Memorandum

To: City of Albuquerque Development Review Board

Date: September 13, 2019

Re: Comment Responses for PR-2018-001670

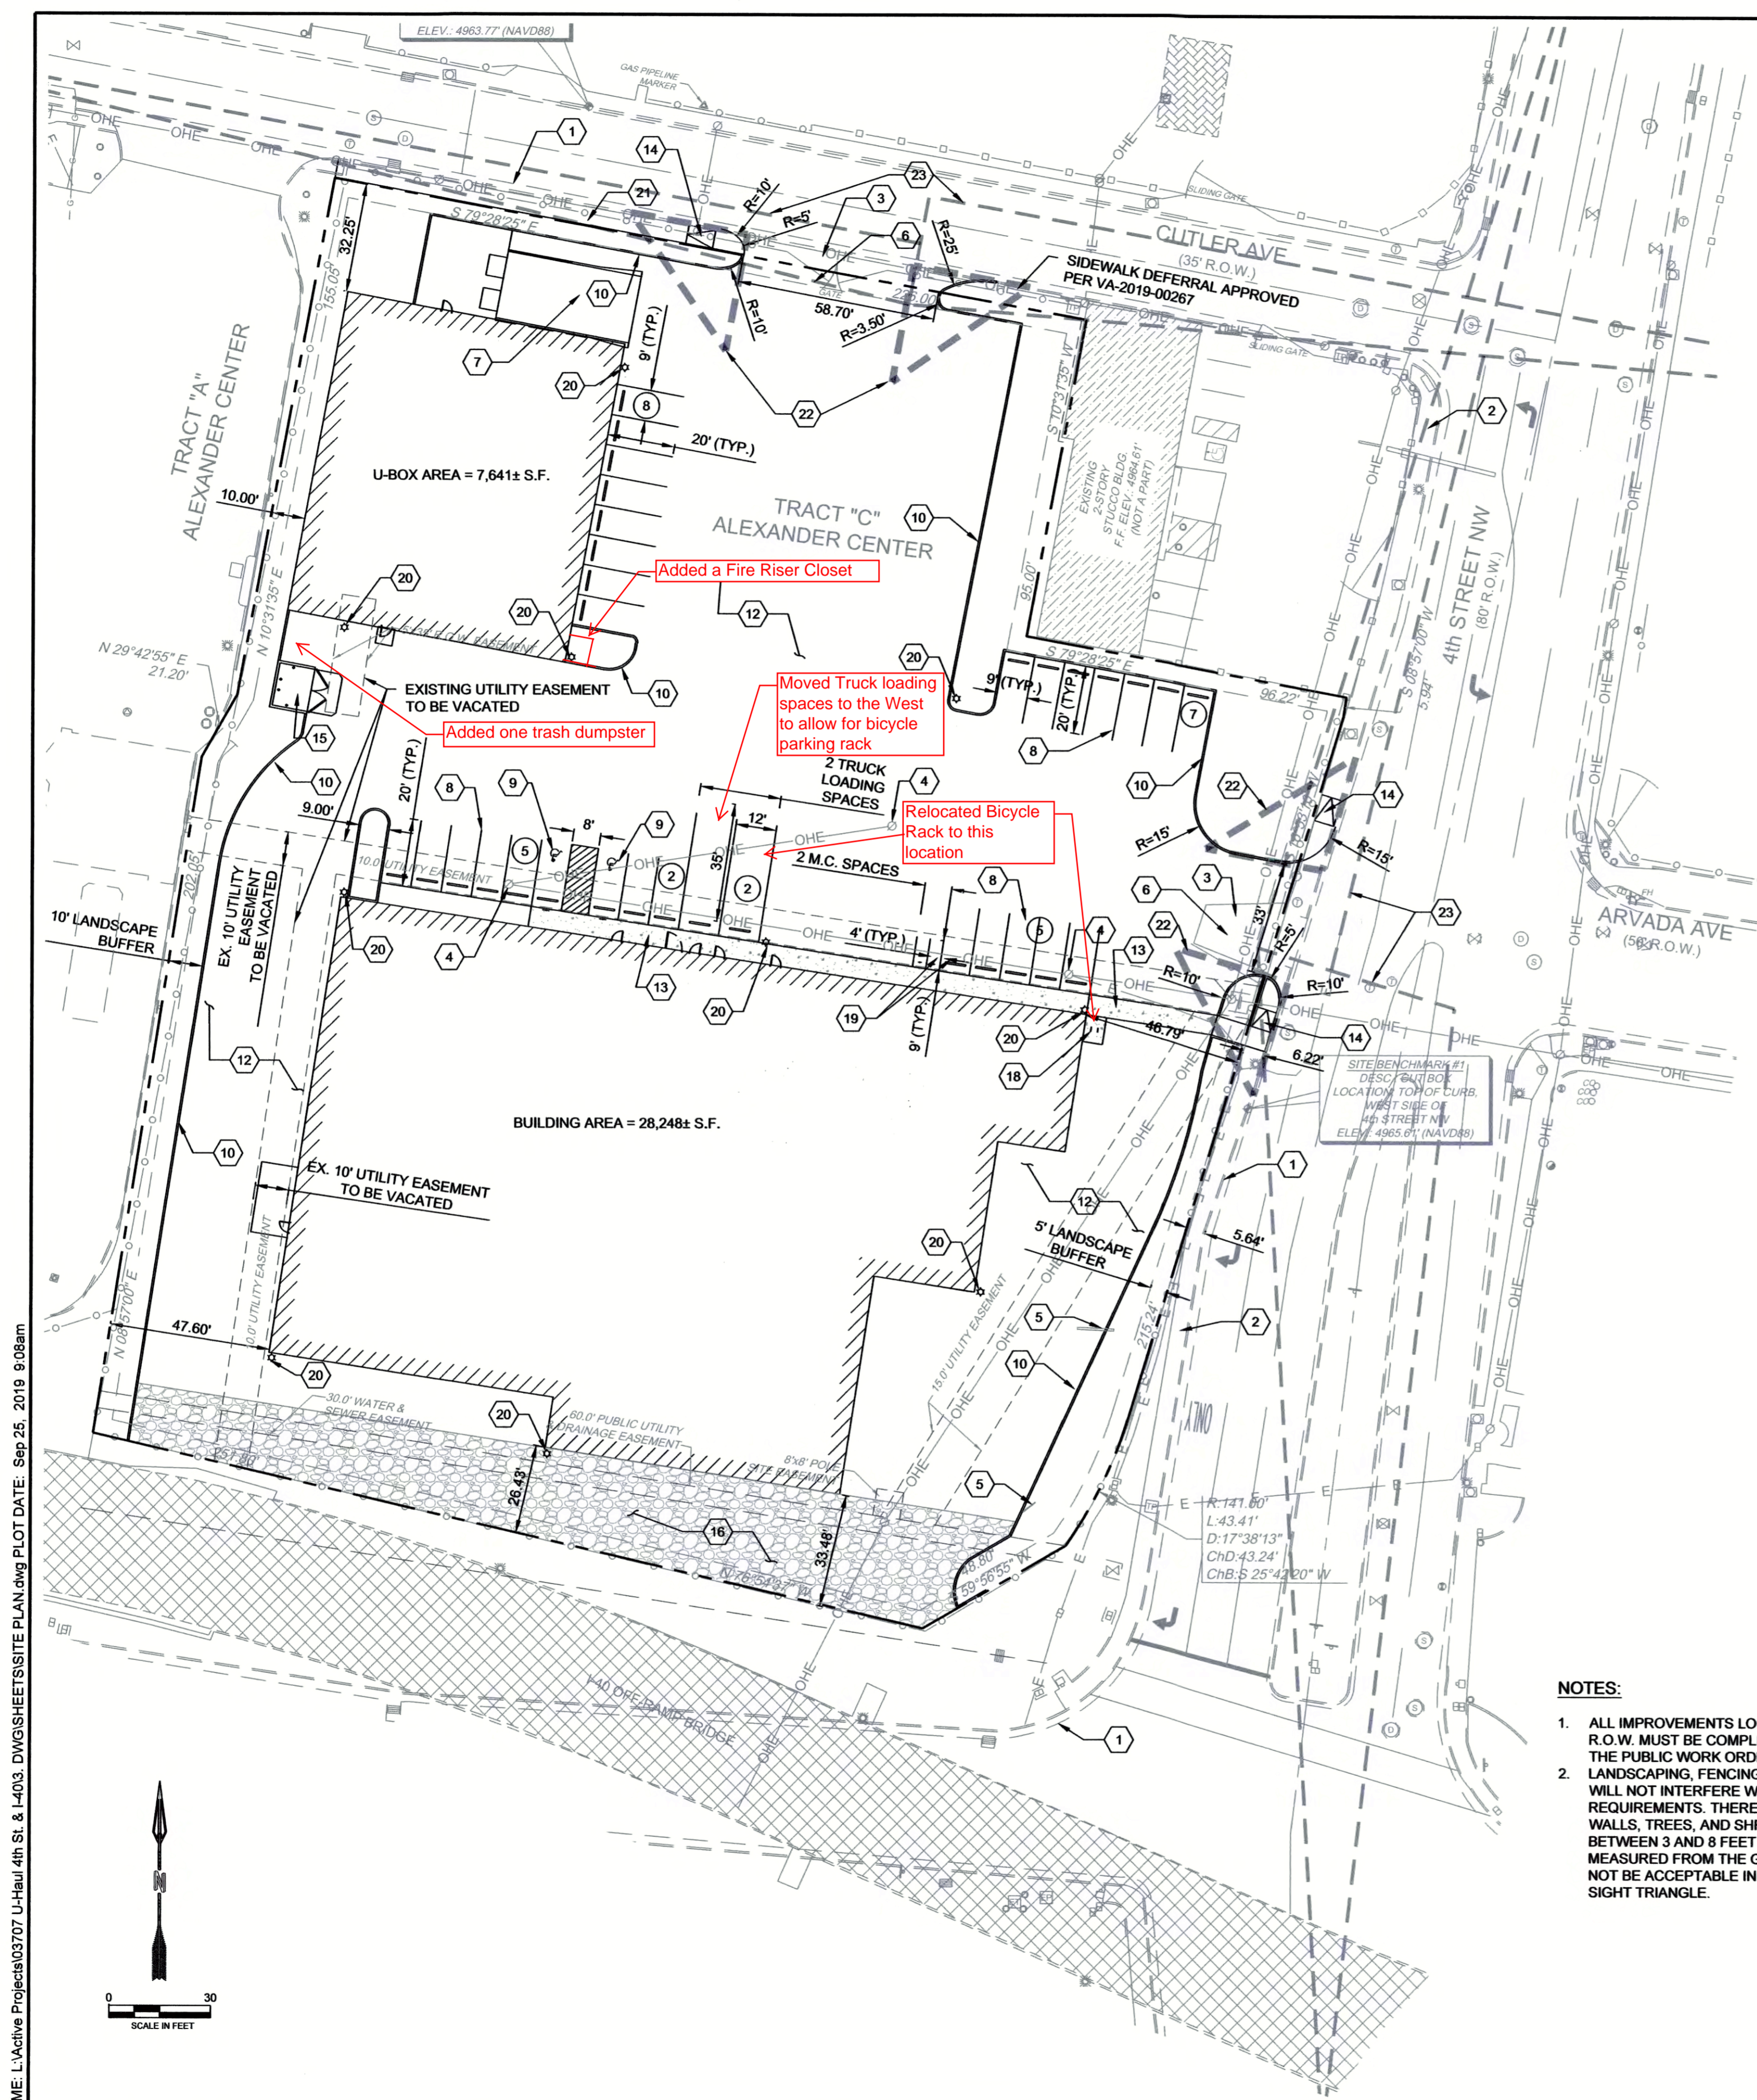
- a. *Noted.*
2. Transportation has no objection to the request for a reduction of sidewalk width on-site from 10 feet to 6 feet.
 - a. *Noted.*
3. Please add the clear sight triangle to each subdivision entrance. Add the following note as well: "Landscaping, fencing and signing will not interfere with clear sight requirements. Therefore signs, walls, trees, and shrubbery between 3 and 8 feet tall (as measured from the gutter pan) will not be acceptable in the clear sight triangle."

- a. *Clear sight triangles and required note added to the site plan.*
4. For the ADA's access aisle words "NO PARKING" in capital letters, these words shall be specified to be at least one foot high and at least two inches wide. The van accessible aisle dimension should be labeled as 8 feet wide.

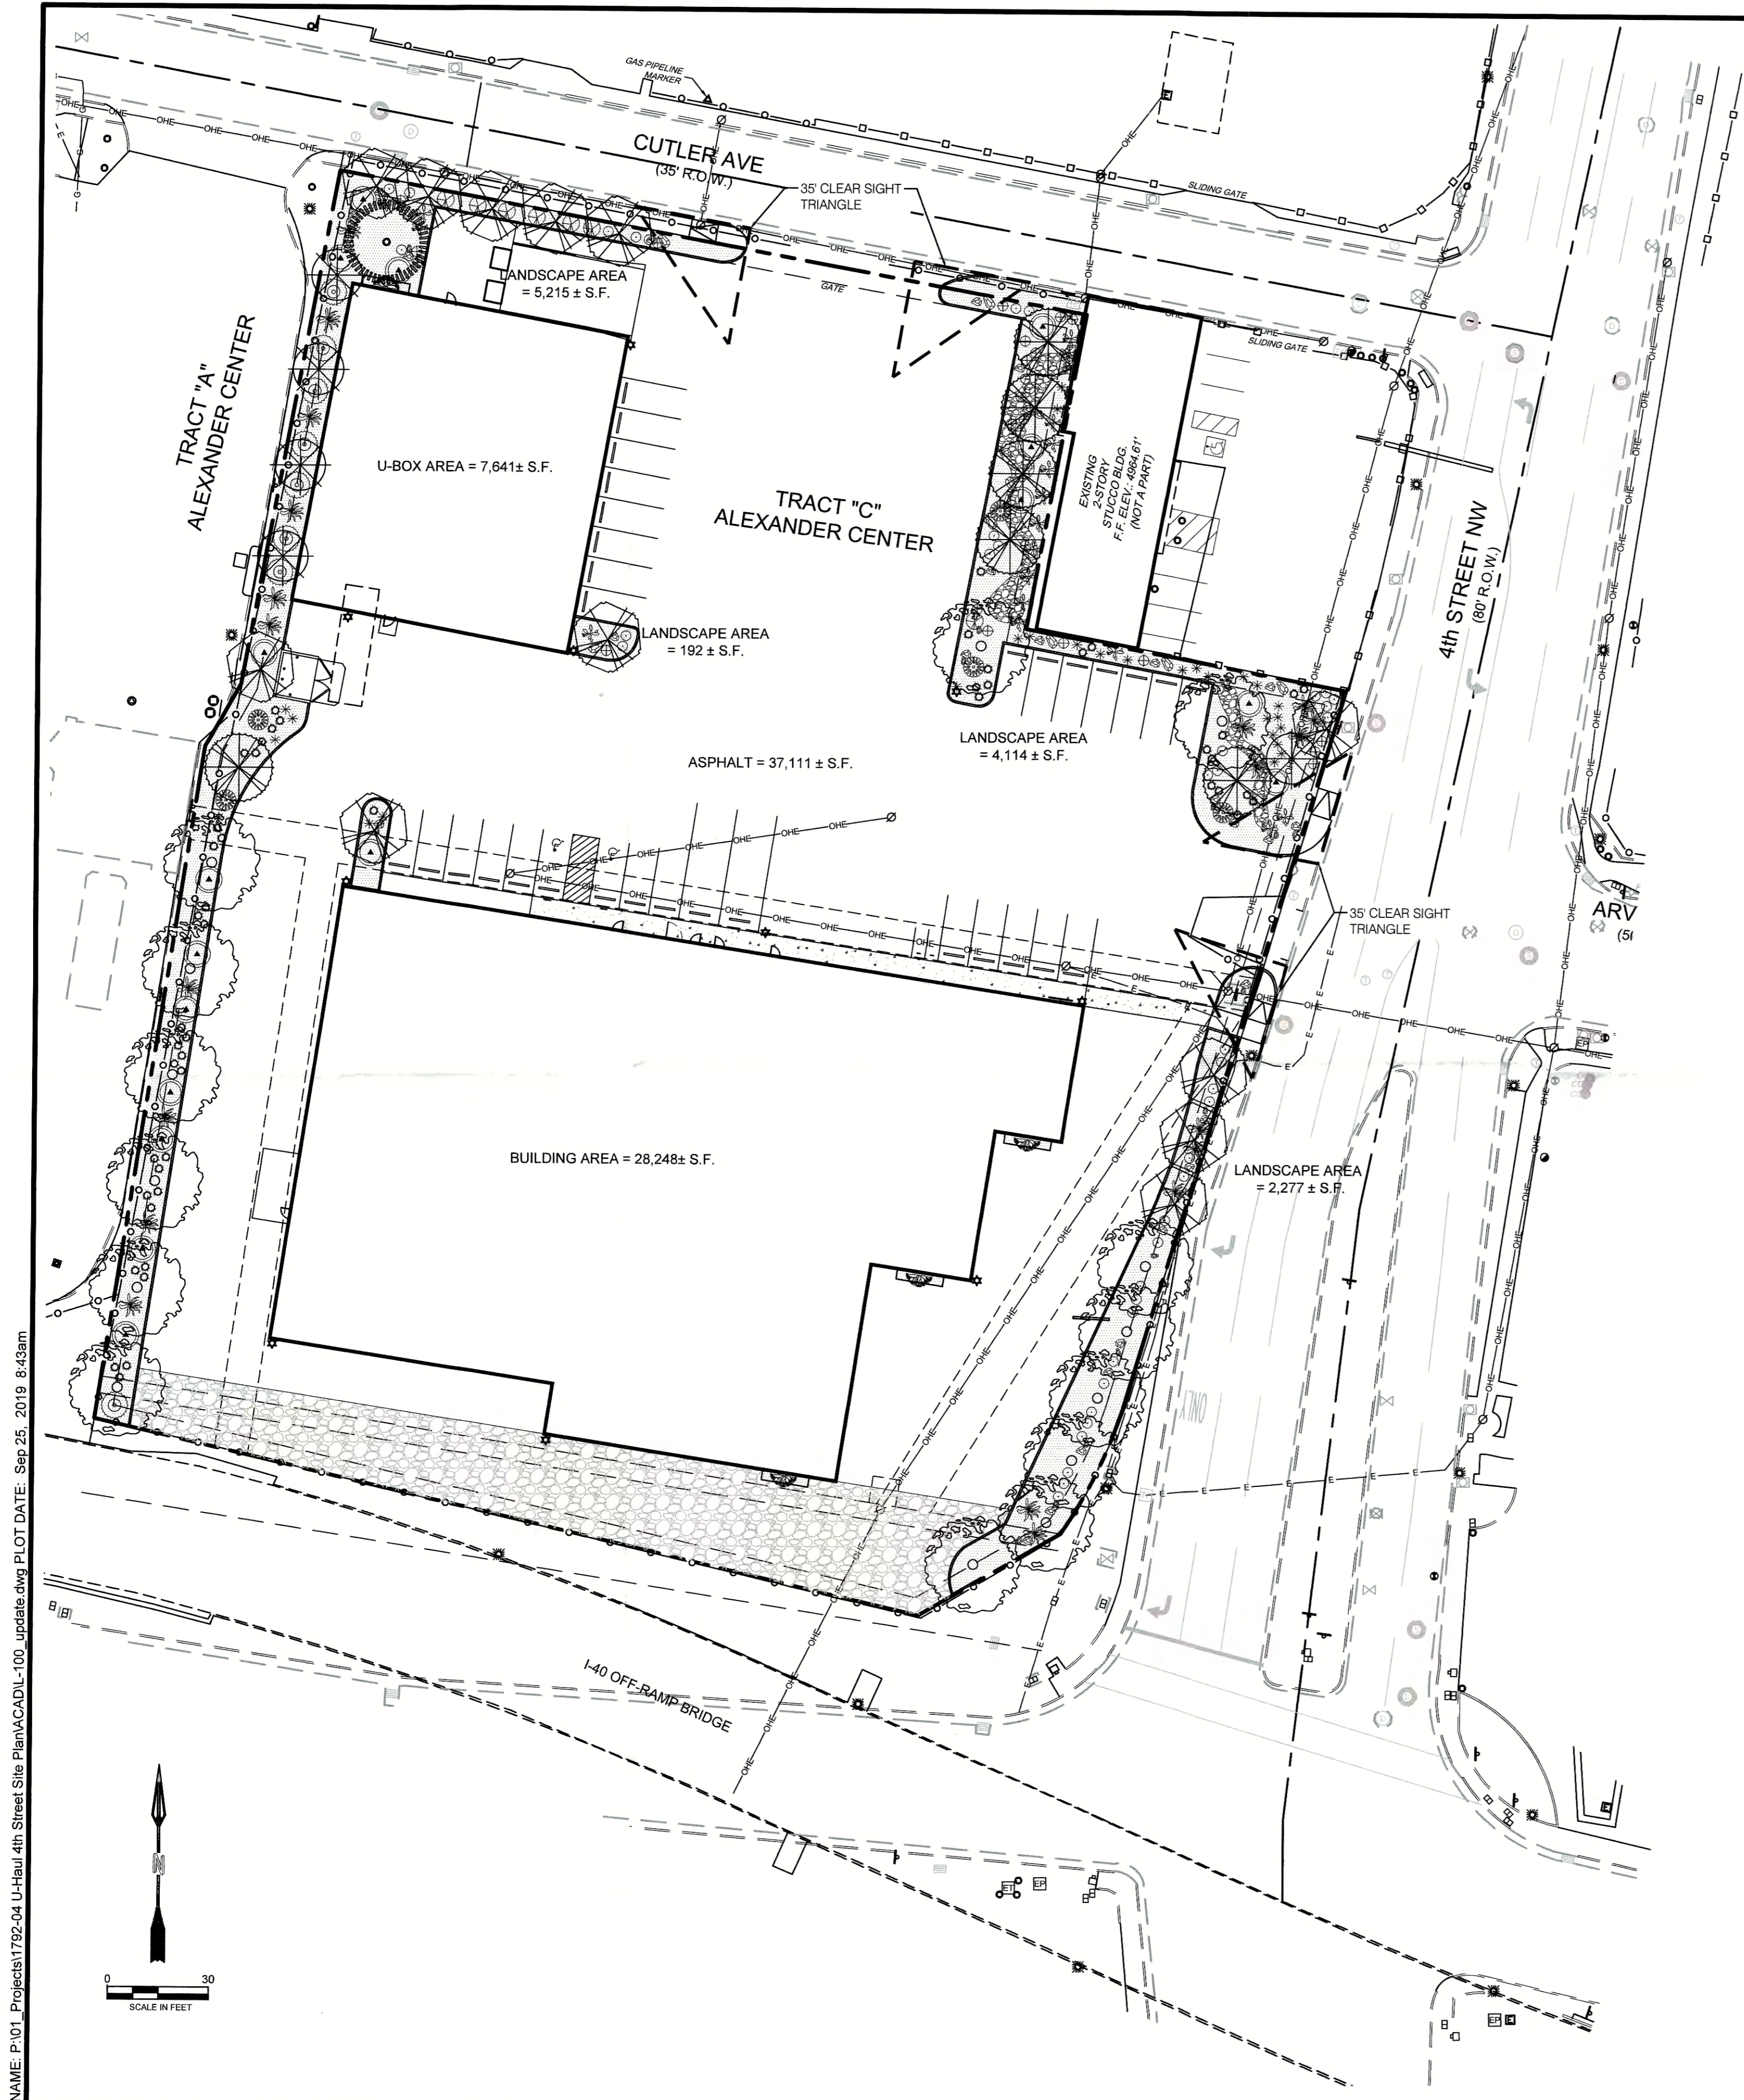
5. Shade trees along required pedestrian walkways are required pursuant to Subsection 14-16-5-6(C)(4)(h) (Required Plant Materials and Site Amenities).
Confirm compliance with section 5-6(C)(5)

- a. *Landscape plan is under review for alternative approval to relocate shade trees to other areas of the site due to limited pedestrian use, location on north side of building, and need to provide for access and circulation for moving trucks. Mulch/gravel placement will be confirmed. Wheel stops are provided on all parking spaces shown on plan.*
